# Project Title: Great Wolf Lodge, Chesterton Planning review

**Ref No:** 0354-RPT-01

### Planning review

This report comprises a review of technical documents submitted as part of a planning application made by Great Lakes UK to develop part of the site currently occupied by Bicester Hotel Golf Club and Spa.

Figure 3-6: UAV Groundwater Survey

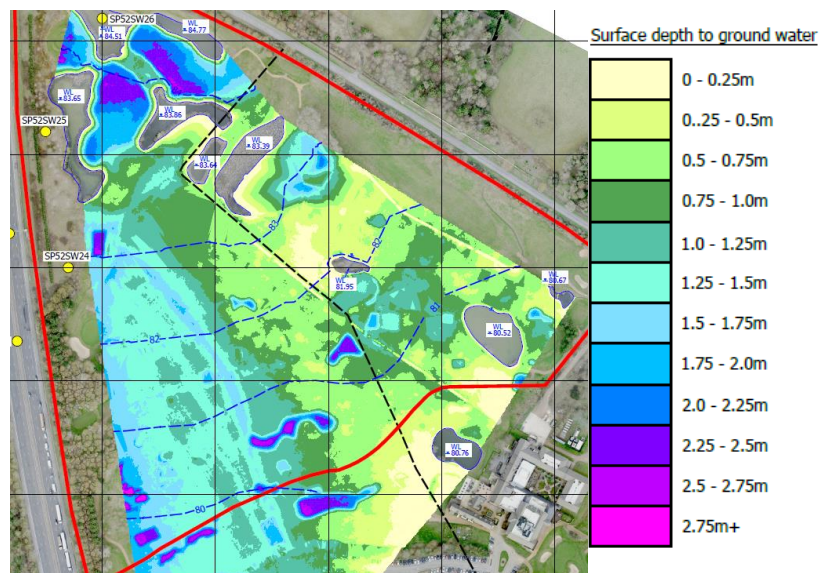
With reference to Section 3.6 of the FRA and 3.1.2 of the Drainage Strategy, groundwater levels have only been ascertained with an unmanned aerial vehicle survey; it should be noted that the sensing method or its accuracy/reliability is not discussed. The survey suggests that the water table is within 1 m of the surface across a large part of the site. Should these results be reliable and represent peak seasonal levels, then there are large parts of the site where infiltration could be feasible, as long as infiltration test results provide favourable results and the proposed infiltrating SuDS devices were of a shallow construction (e.g. shallow infiltration basins or shallow infiltrating modular storage below car parking areas).
